Subject: FW: Planning Application FP/258/19/PL - 107 Felpham Way, Felpham

Subject: Planning Application FP/258/19/PL - 107 Felpham Way, Felpham

Richard Wickens - Clerk to Felpham Parish Council

Figure 4.3 Survey Area and Maximum Parking Capacities

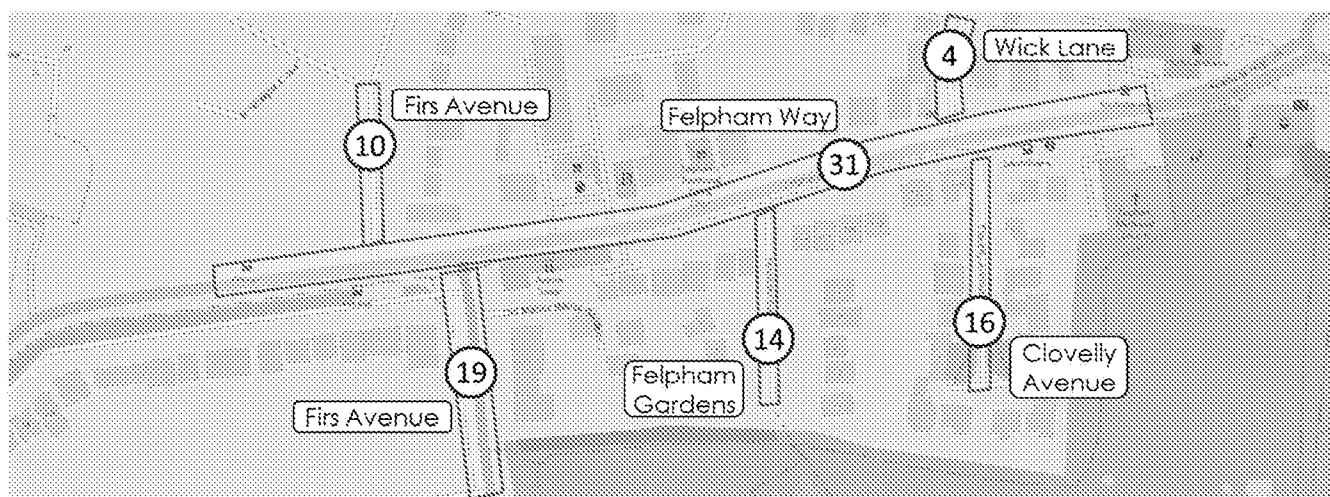
The applicant submitted a "Lambeth Survey" which indicated that following a survey (which has to be carried out at 0500 hours or thereabouts) there were 81 free on street parking spaces within 200 metres of the development. This includes and I quote " 31 space in Felpham Road". **Felpham Road** is not within 1 minute walk of the site as it is the road passing St Marys Church! What they mean I am sure is **Felpham Way**. However not very professional to make such a fundamental error in a public report! The Lambeth survey has been accepted as mitigation to the ADC policy by the Planning Officer. However as locals we know that this parking will be on the north side of the Felpham Way (as yellow lines on the south) and most will seek to park there with a roundabout, pedestrian crossing and a garage entrance and exit in close proximity or down Summerley Lane. The survey has not been circulated so it is difficult to confirm where these 81 spaces are that are all within 200 metres? **Please could the Parish Council have sight of the results etc form the Lambeth Survey carried out by the applicant?**
